**MARK D. FRANCIS**  
**ATTORNEY AND COUNSELOR AT LAW**

January 10, 2019

*Re: BOA-18-008*  
*Response to Letter of November 28, 2018 re 13980 Black Forest Road and 6770 Jicarilla Drive*

PCD FILE NO. BOA 88

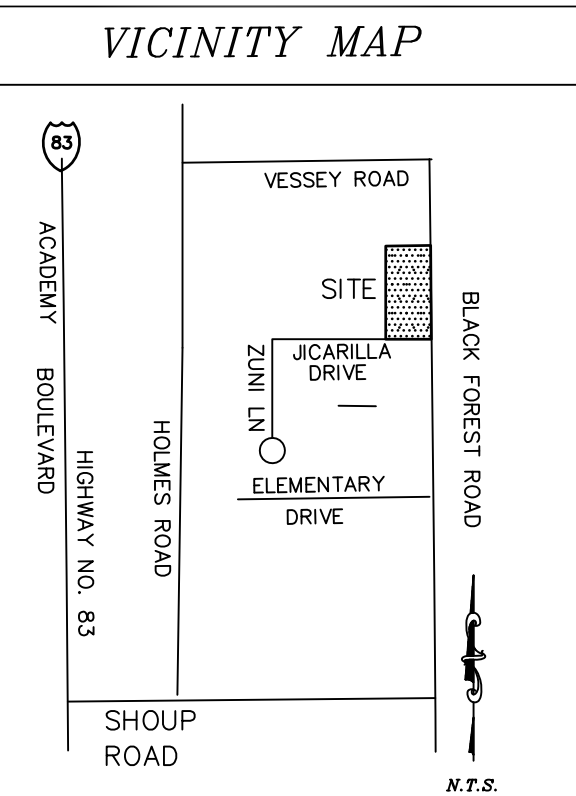
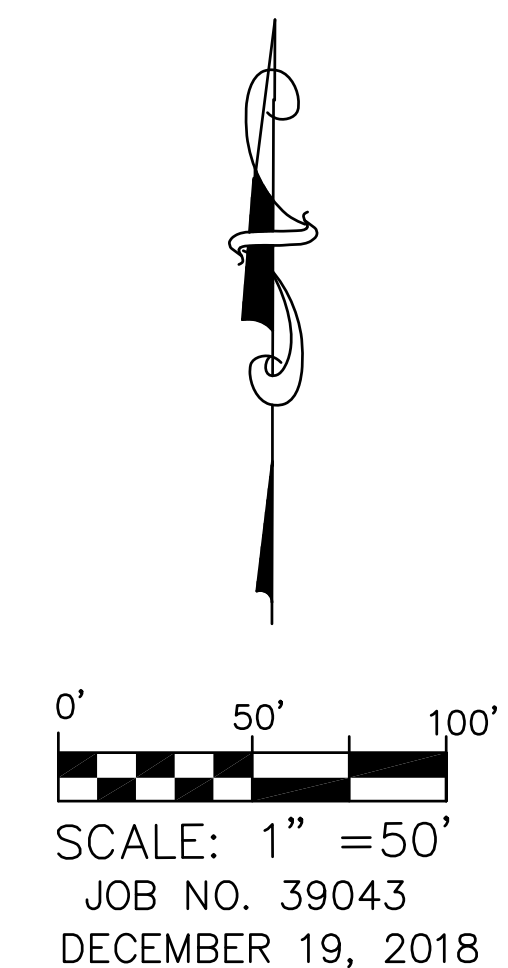
To address further comments, the Applicant notes that right of way dedication in the future will reduce each of the two remaining lots by 6,355 square feet of land area or .14 acre. The final lot sizes will be 2.36 acres. The Austin lot to the north will likewise be reduced to 3.52 acres after the ROW road expansion, and the lots on the east side of Black Forest Road will be reduced in size to 4.64 acres and 9.28 acres. The Nichols parcel to the South drops in size to 4.20 acres. This is all shown on the attached revised site drawing.
